I note in the local paper 'The Bognor Observer' there is an application for planning permission to build 2x2 bedroom bungalows on the land behind numbers 17 to 23 Greencourt Drive. Ref number BE/44/25/PL.

This planning application BE/44/25/PL is not in keeping, or of the same design as the rest of the street, and it will have a detrimental effect on the neighbours.

<p>Title</p> <h1>Site Plan - As Proposed</h1>			
<p>Date March 23</p>		<p>Drawn By</p>	<p>NJ</p>
Job No.	Drawing No.	Scale	Revision
W22-020	102	1:100@A1	A

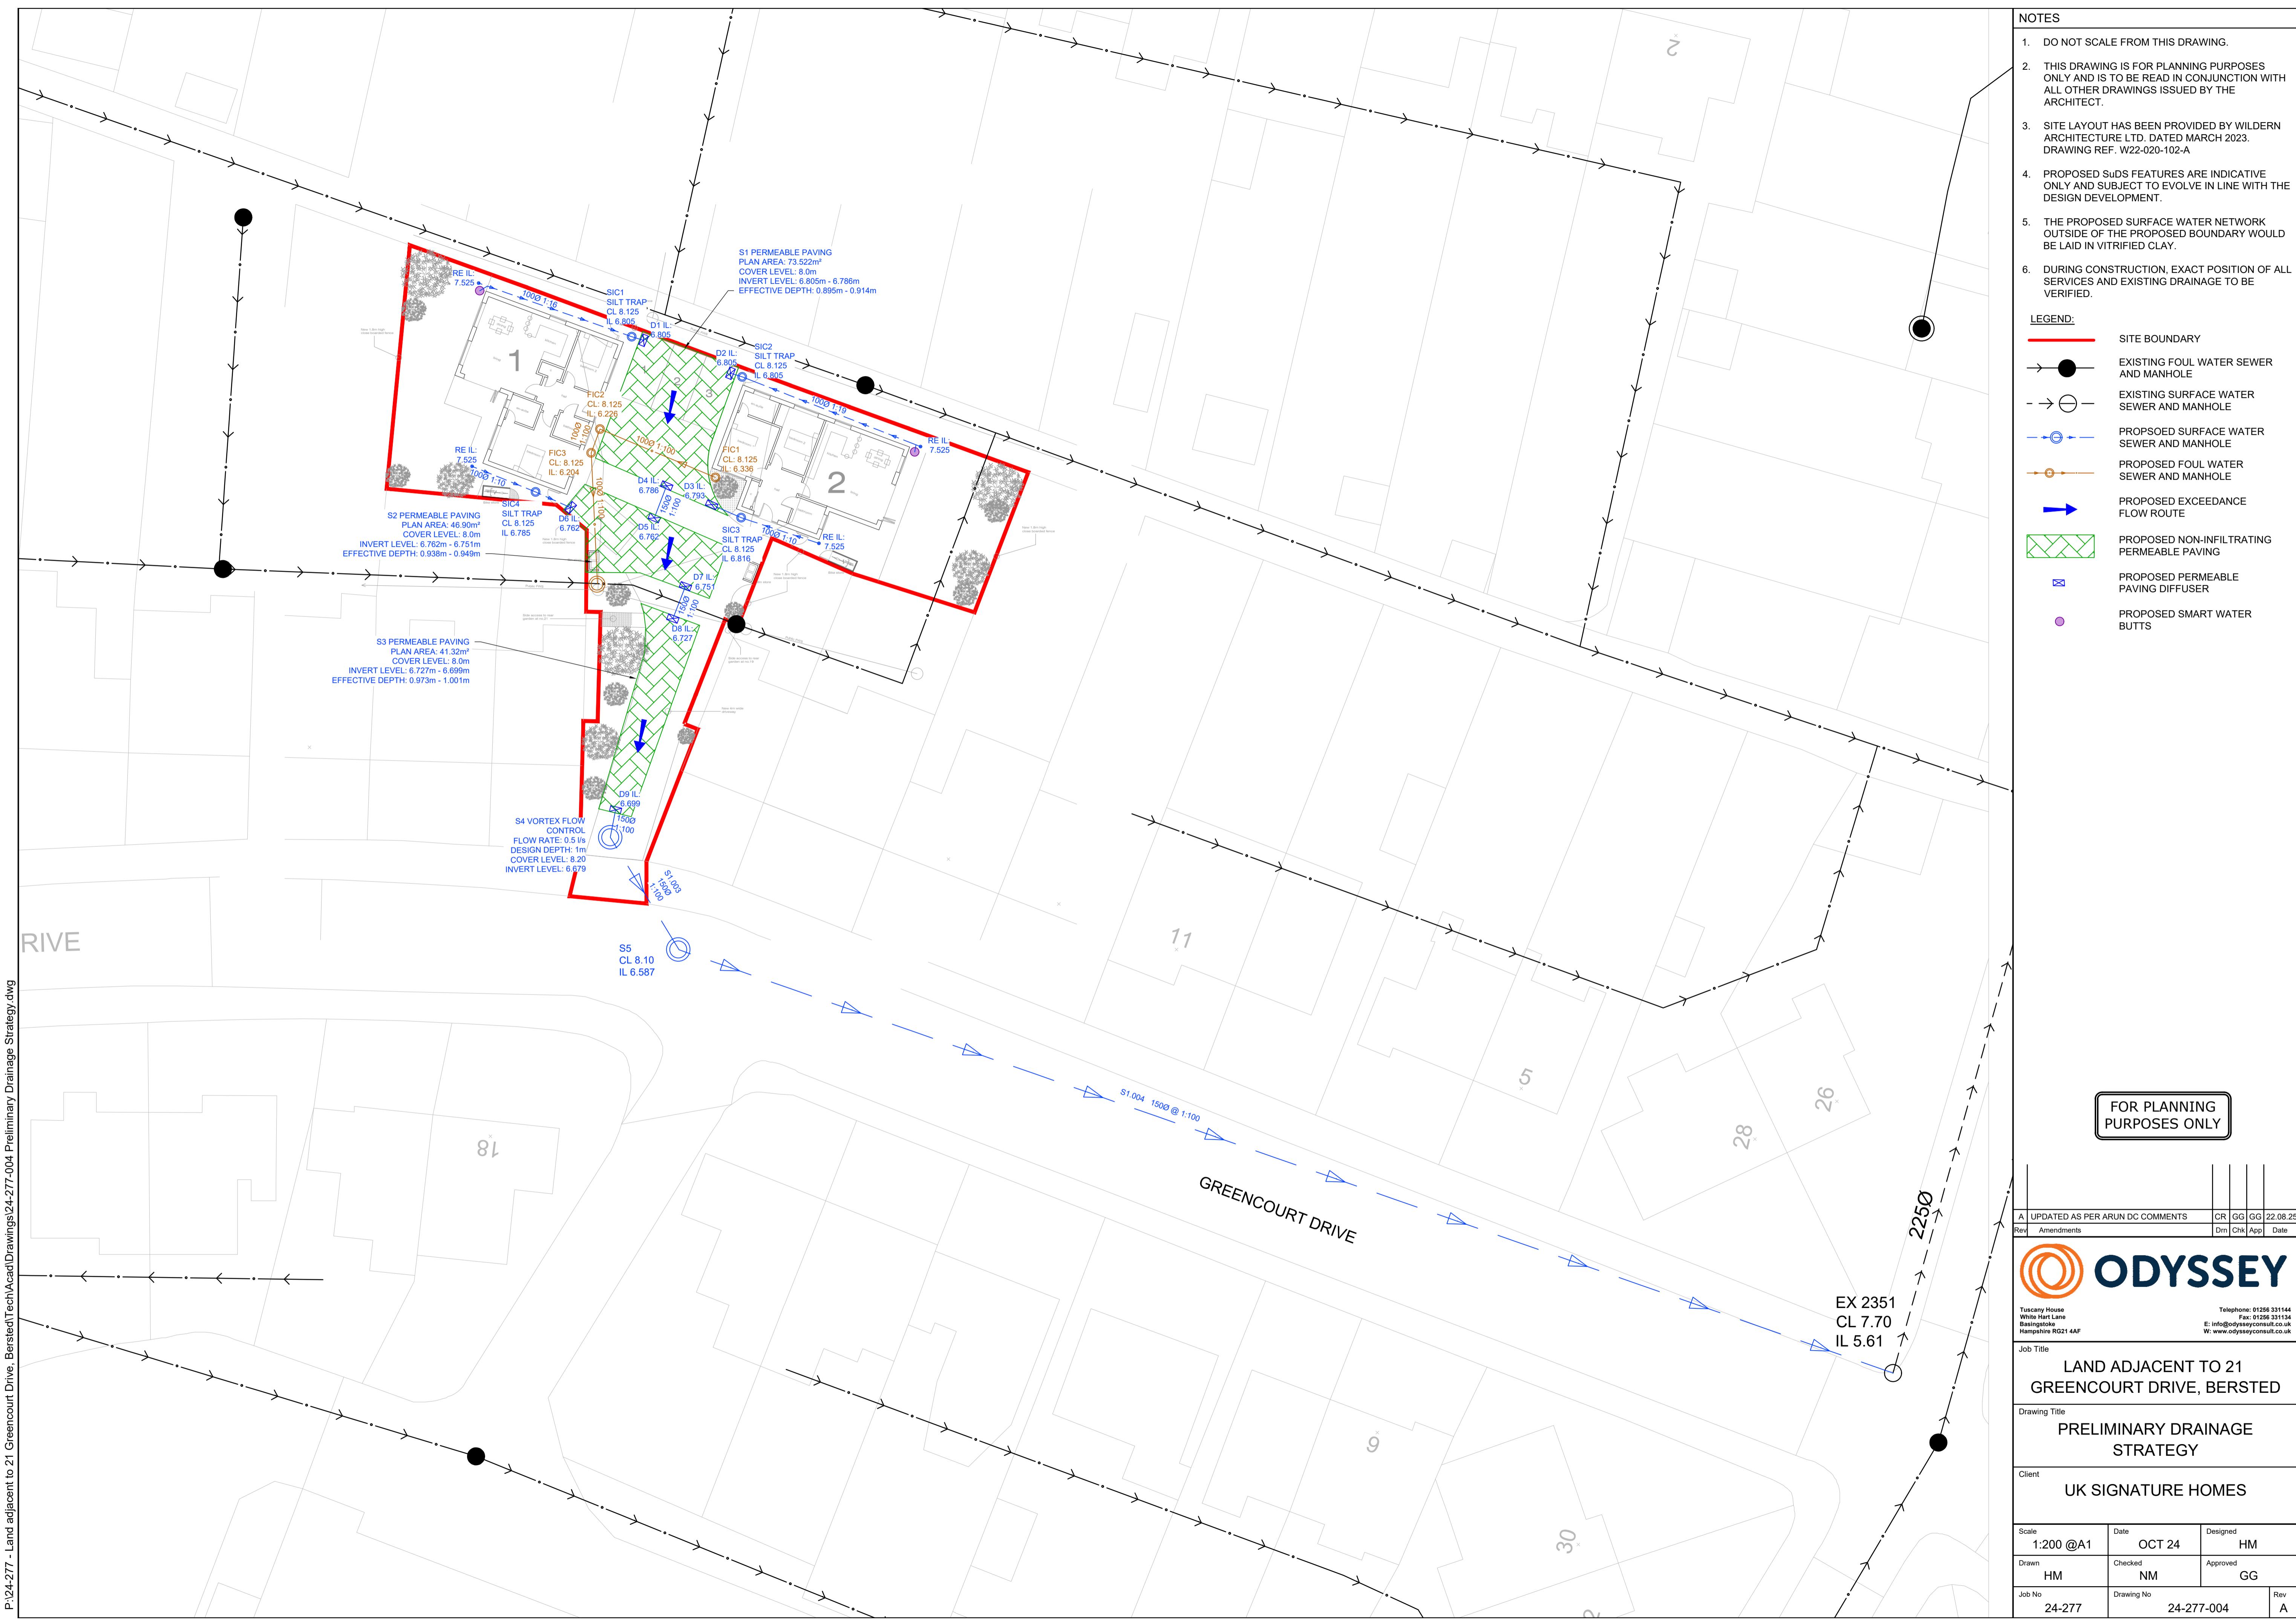
(a) Overdevelopment in a quiet residential area. When the builder 'Neals of Chichester' developed this estate they made provision for adequate garden space to be enjoyed by families. This planning application leaves only a very small back yard with no play space for children. These houses 17-21 will suffer from lack of privacy.

(b) The driveway into the development is too close to the sides of houses 19 and 21. Small children coming out from the side doors are stepping into the path of moving vehicles. This is a Safety Issue; an accident waiting to happen.
